**August 24, 2011  
DRB Comments**

**PROJECT # 1008953**

**RE: Lot C, Sandia Addition**

SITE PLAN FOR SUBDIVISION
5207 San Mateo
(Former Rowlands Site)

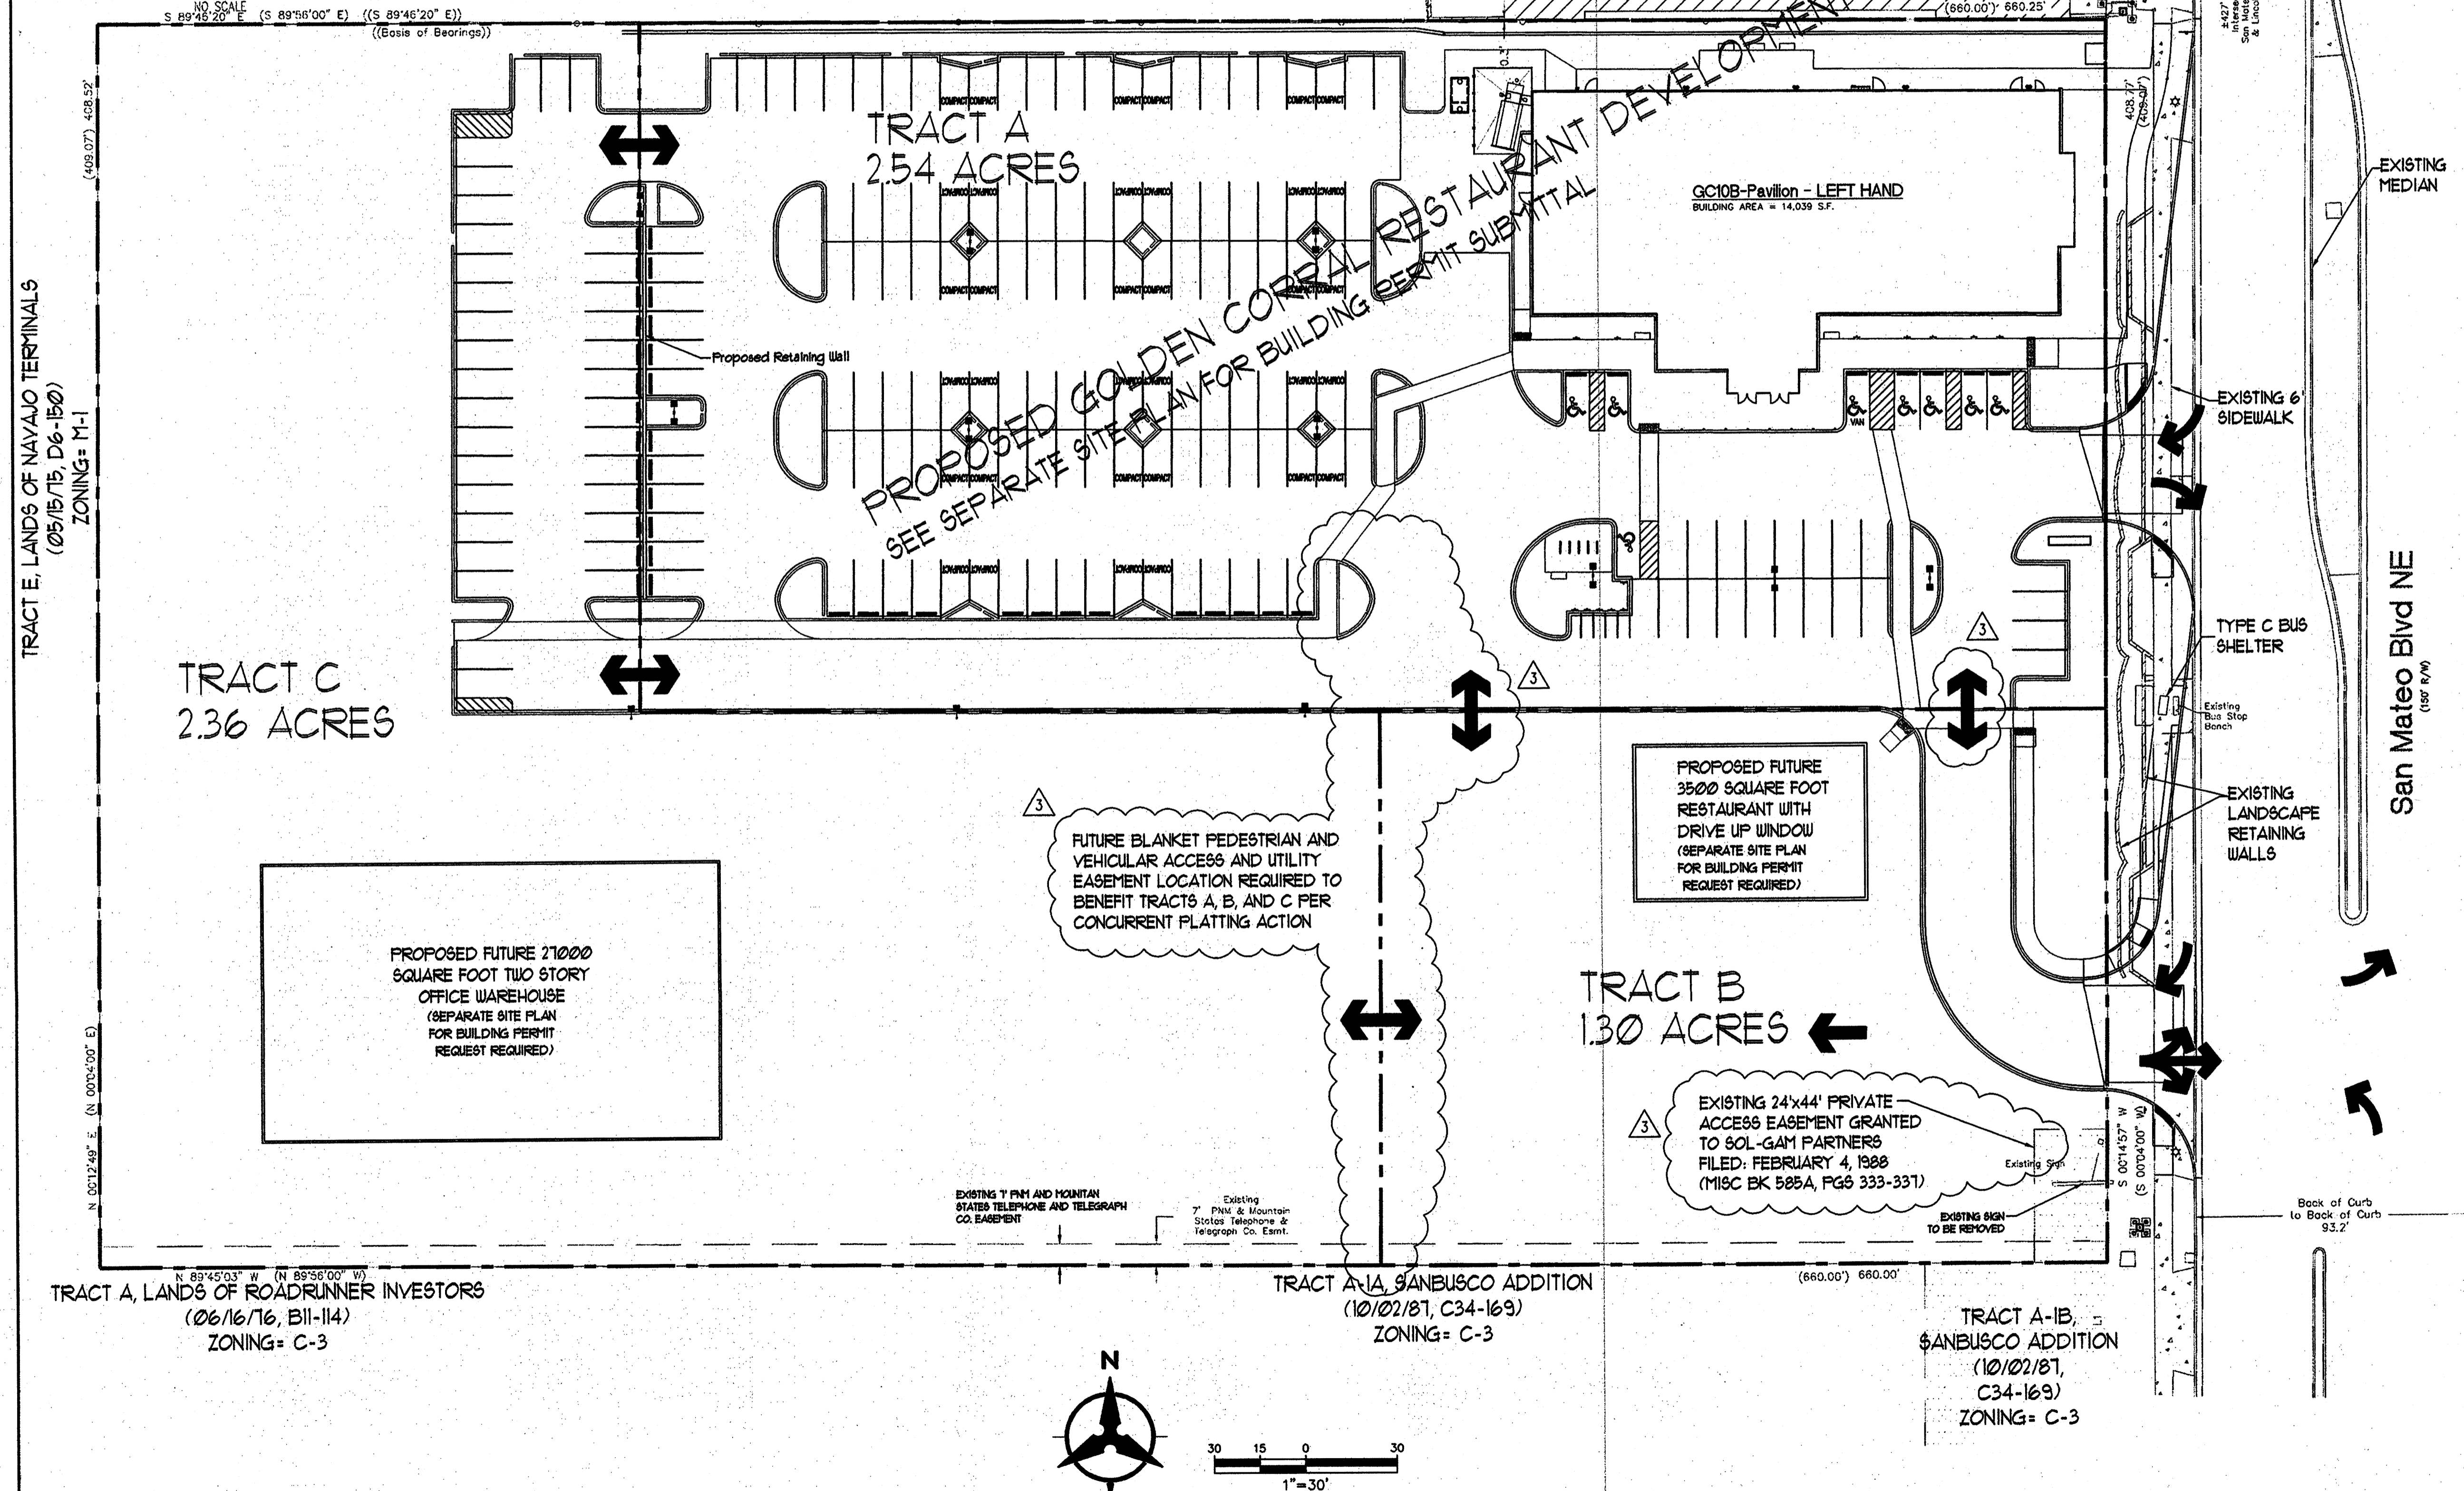
A Conditional Use Permit is required for the proposed use. Refer to the O-1 zone for development requirements (26' height, 5' setbacks on side and rear, 11' setback from entrance. Refer to § 14-16-3-10 of the Zoning Code for landscaping regulations and § 14-16-3-1 of the Zoning Code for parking requirements.
